Subject: 40 O'Brion Street Redevelopment
Re: Ability to Serve

Attn: Olivia Dawson
Re: 42 Obrion Street - Portland
Ability to Serve with PWD Water

The Portland Water District has received your request for an Ability to Serve determination for the noted site submitted on March 16, 2016. Based on the information provided, we can confirm that the District will be able to serve the proposed project as further described in this letter.

DRAWING NAME: **UTILITY PLAN**
 PROJECT NAME: **40 O'BRIEN STREET RESIDENTIAL INFILL**
 CLIENT: **215 FORESIDE ROAD, FALMOUTH, MAINE 04105**

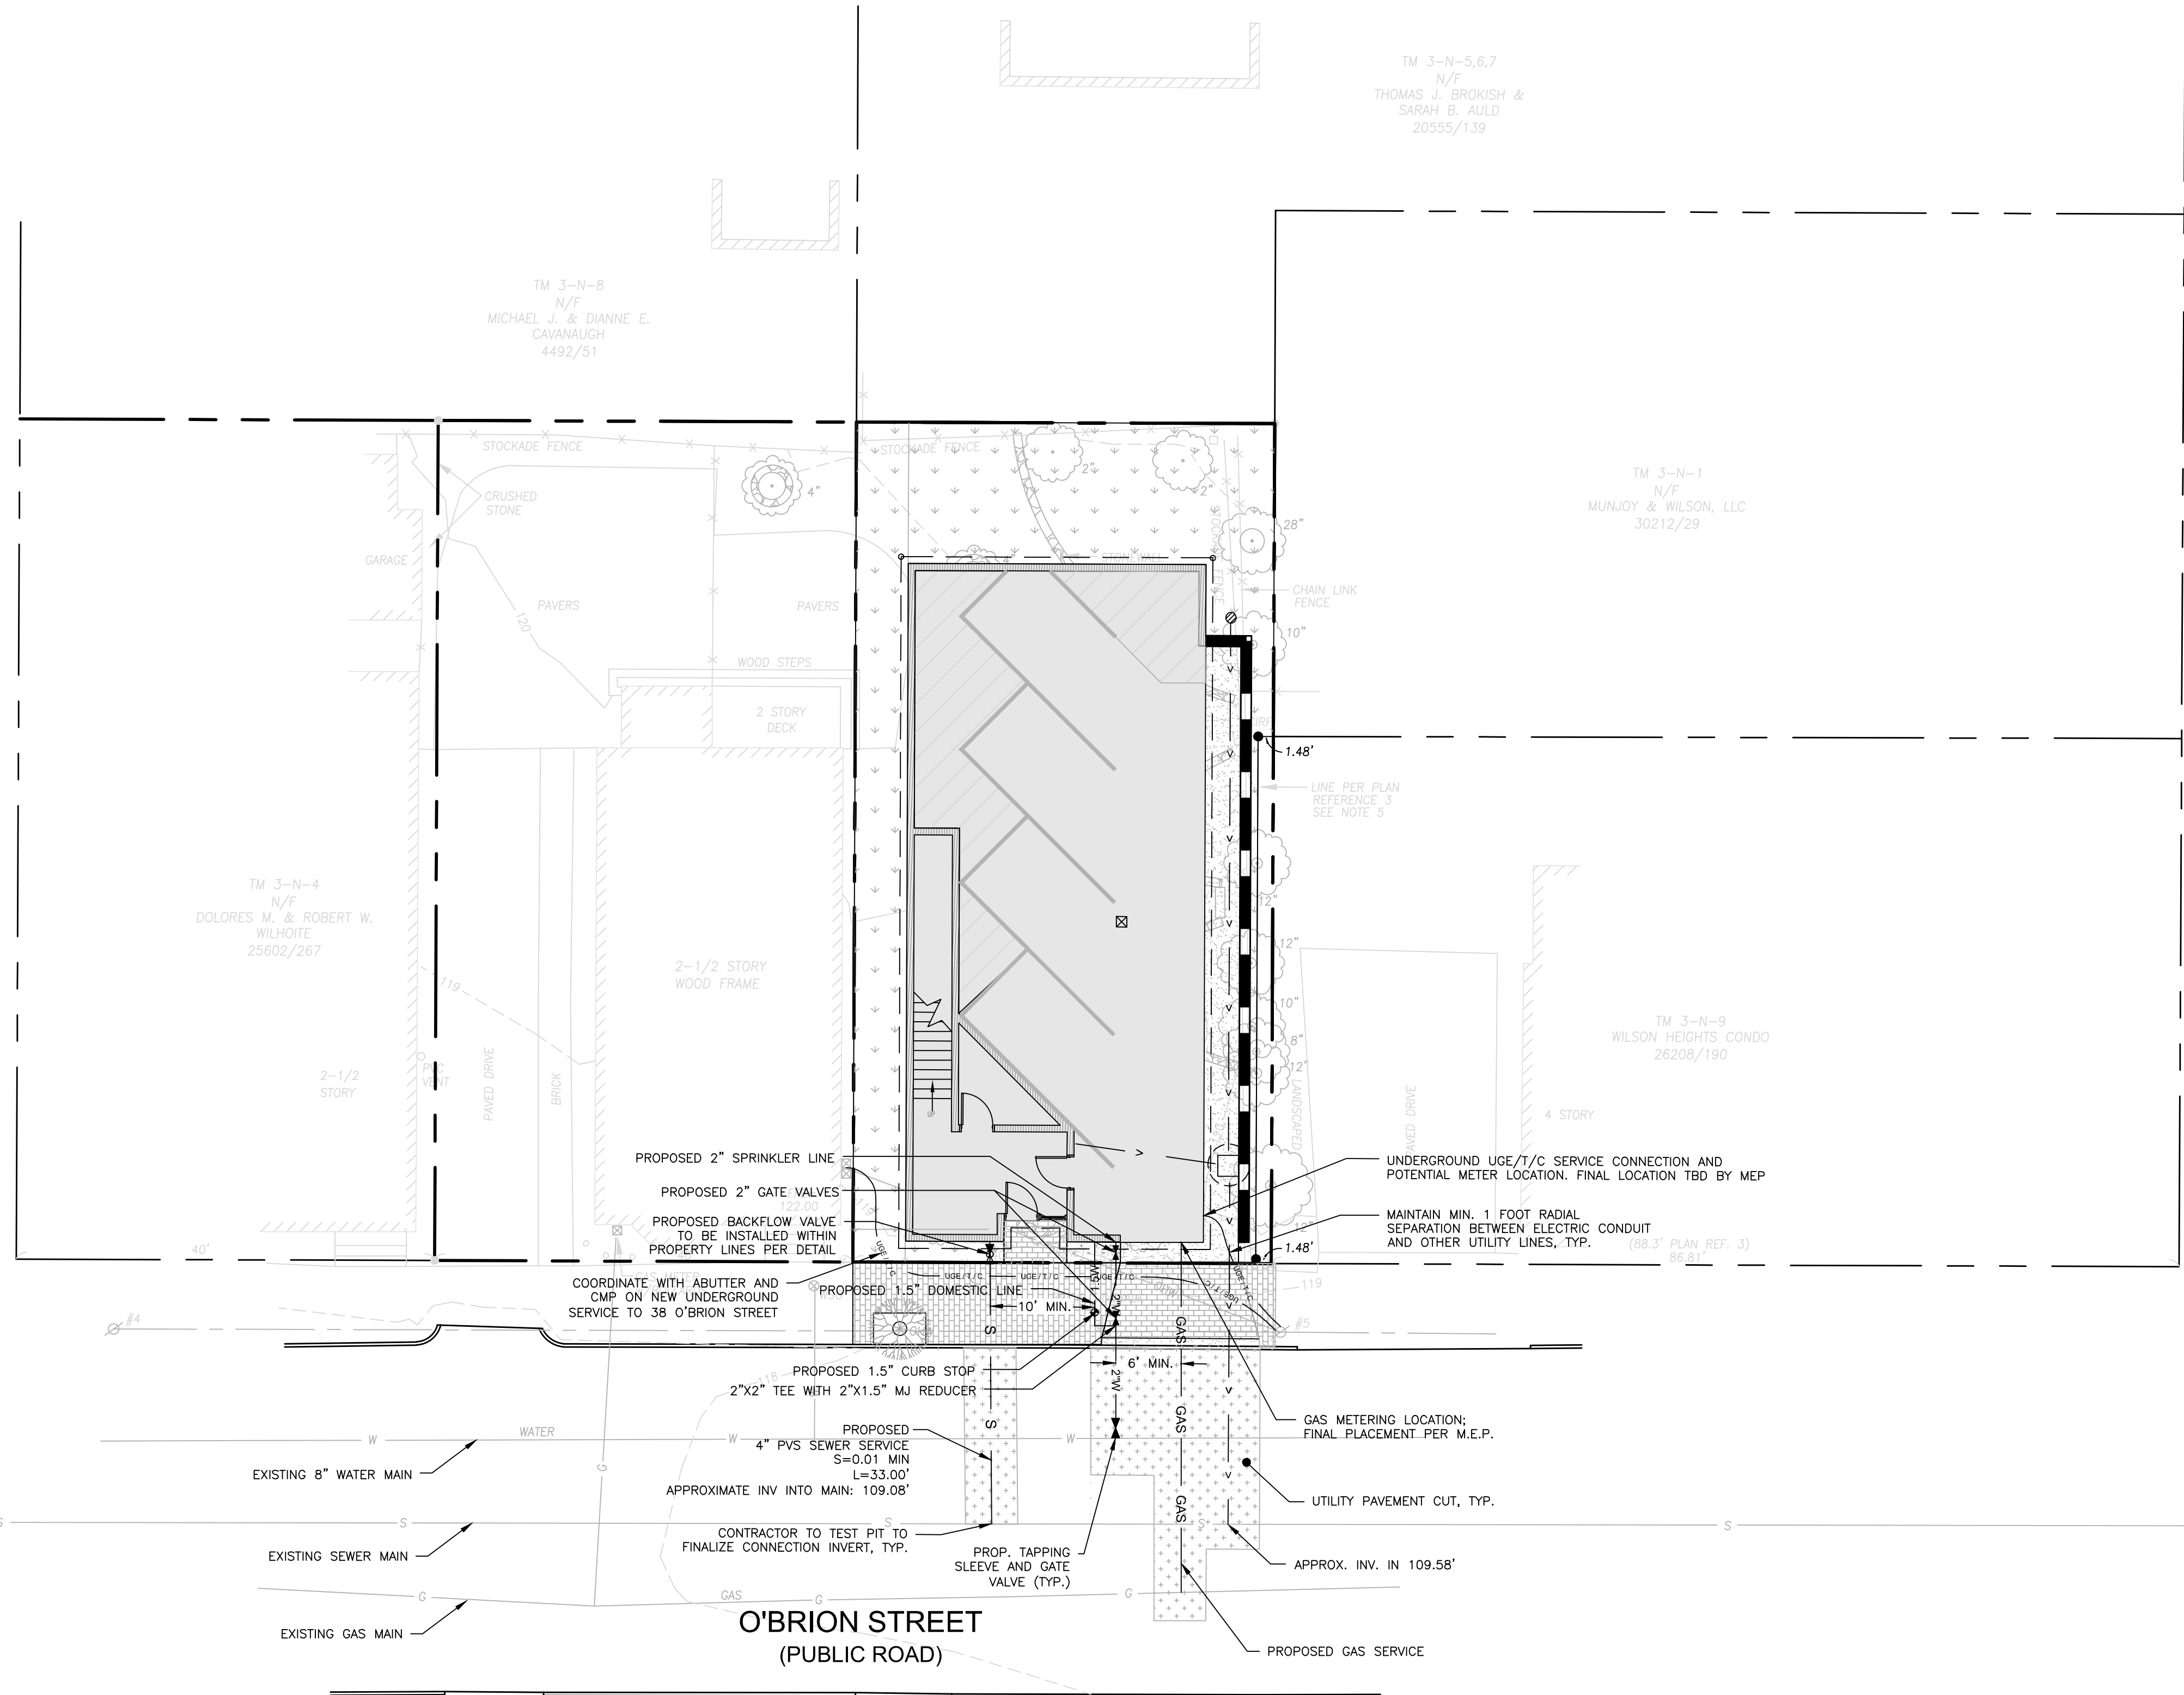
- A 2-inch fire and 1.5-inch domestic service may be installed from the water main in Obrion Street. The services should enter through the properties frontage on Obrion Street at least 10-feet from any side property lines. The layout of the services as shown on the plans you submitted labelled Utility Plan, C-10 dated 1/22/16 are acceptable to the District with one exception. Both streetline shutoff valves must be located 6" into the road right of way.

- Based on the fixture count you provided, we have calculated a peak flow of 23.3 gallons per minute. The proposed 1.5" domestic service will provide up to 66 gallons per minute. A 3/4" meter will provide up to 30 gallons per minute. We will also need confirmation from the sprinkler designer that the 1.5" domestic tap off the 2" fire service is acceptable.
